**NORTHBANK ENTERPRISE HUB PTY LTD (MP 10\_0185)  
PROPOSED INDUSTRIAL & BUSINESS PARK**

Reference is made to your letter to the Environment Protection Authority (EPA) dated 10 September 2012 requesting a review and detailed submission on the report titled "*Environmental Assessment Report: Northbank Enterprise Hub Pty Ltd*" (EA) dated 24 August 2012.

### **ENVIRONMENT PROTECTION AUTHORITY NORTHBANK ENTERPRISE HUB PTY LTD (MP 10\_0185) PROPOSED INDUSTRIAL & BUSINESS PARK**

Figure:
6-6

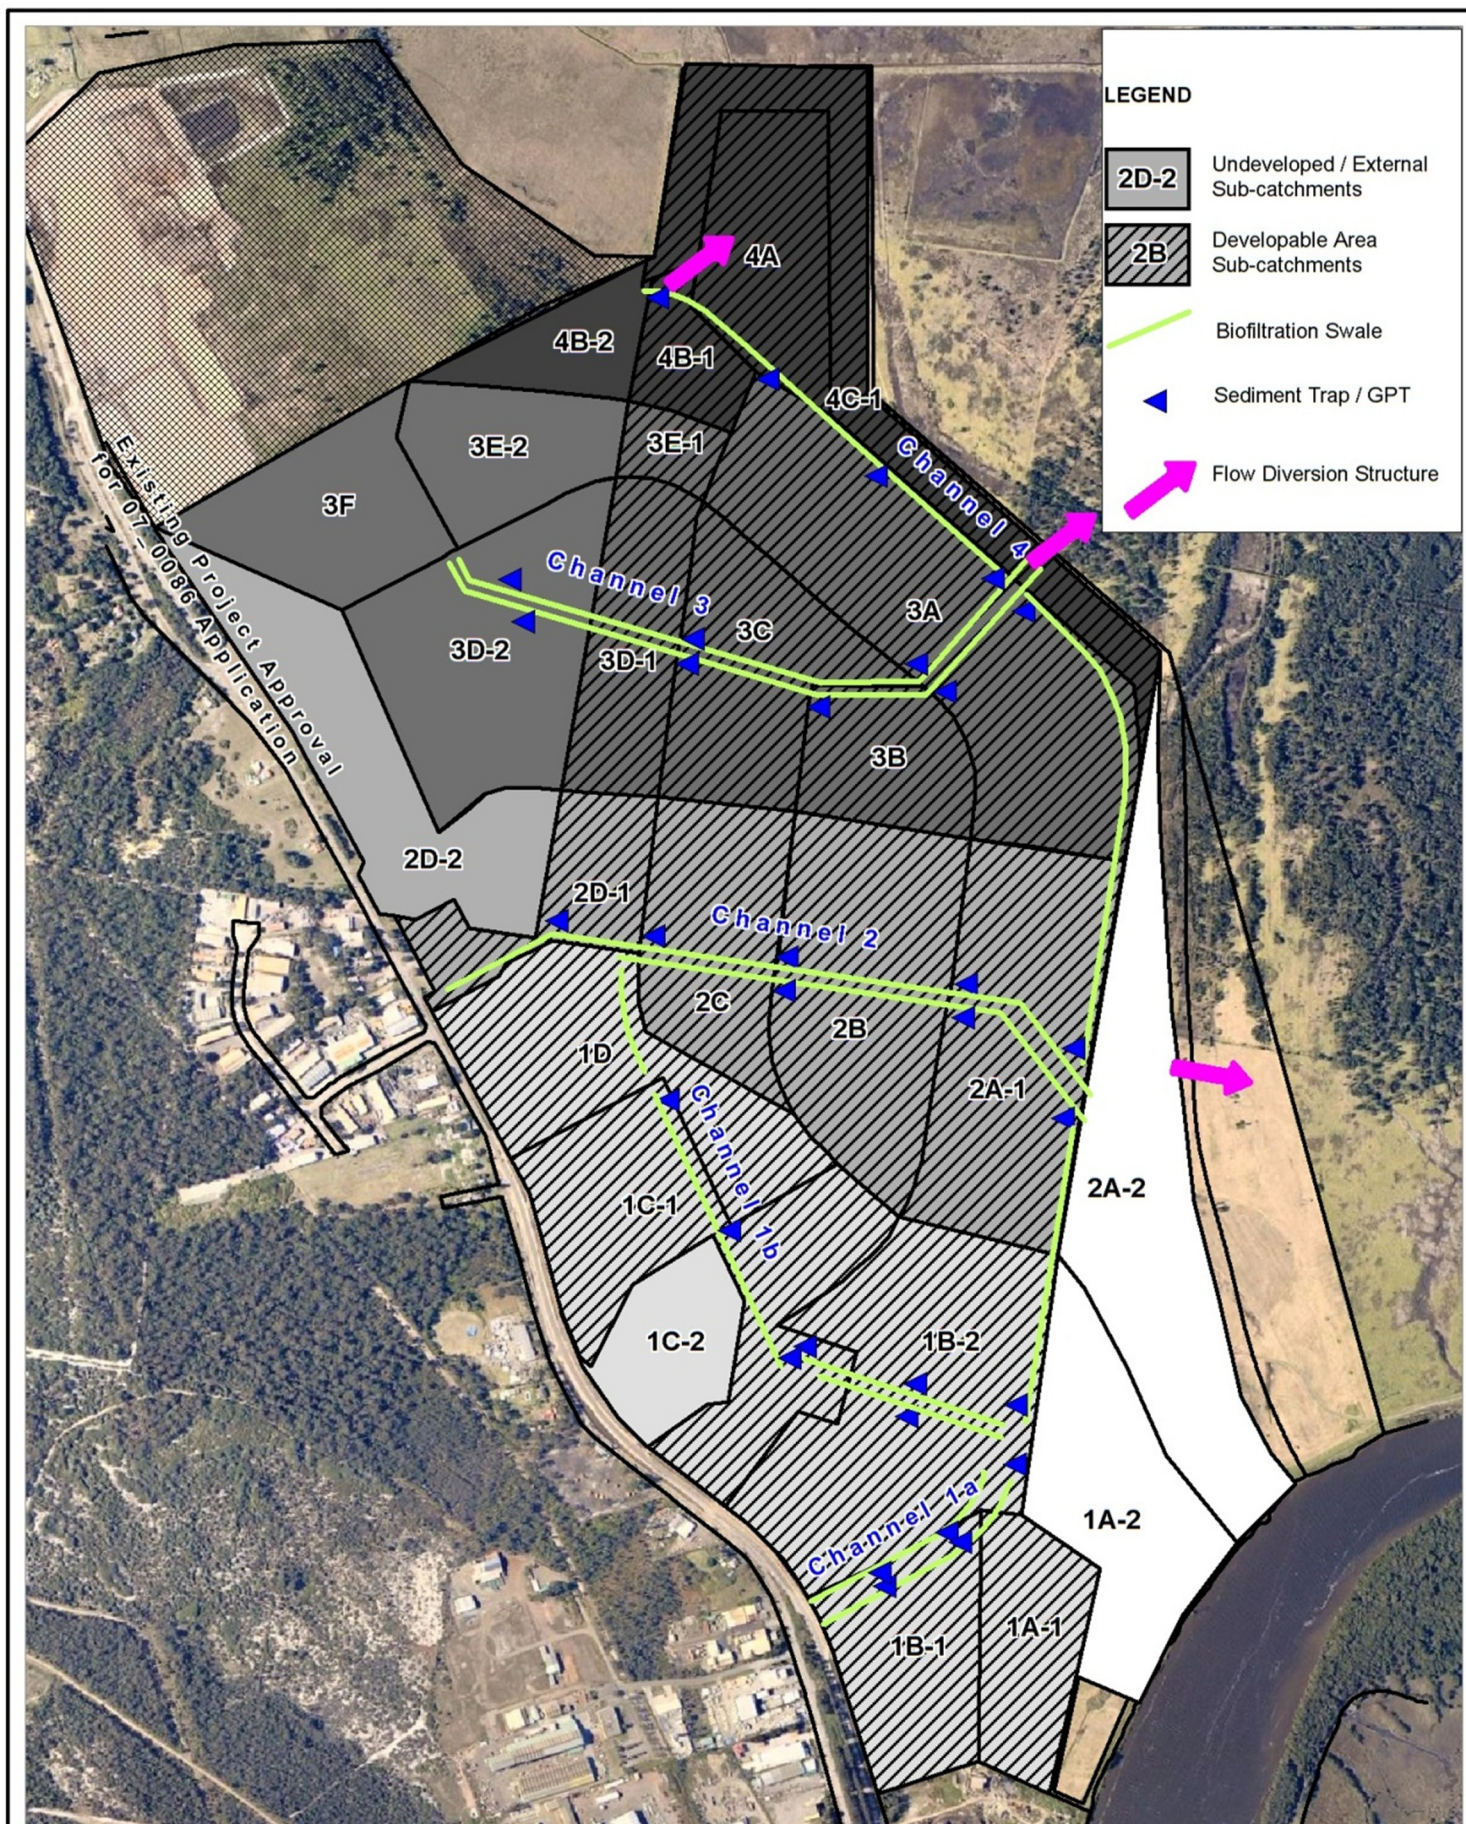
Figure 19 of the EA (Figure 6.6 of the Stormwater Assessment) shows flow diversion structures directing stormwater into a Area 4A (which EPA understands is now part of a negotiated ecological offset for the site) and also fresh water diversion into the premises south of the site. The EPA is concerned that there are no discernable directions of where the stormwater will flow as the diversions suggest that the water will be directed offsite and onto other sites. The figure also does not show where water flows will enter the Hunter River. This matter needs to be clarified and resolved before further consideration should be given to the proposal.
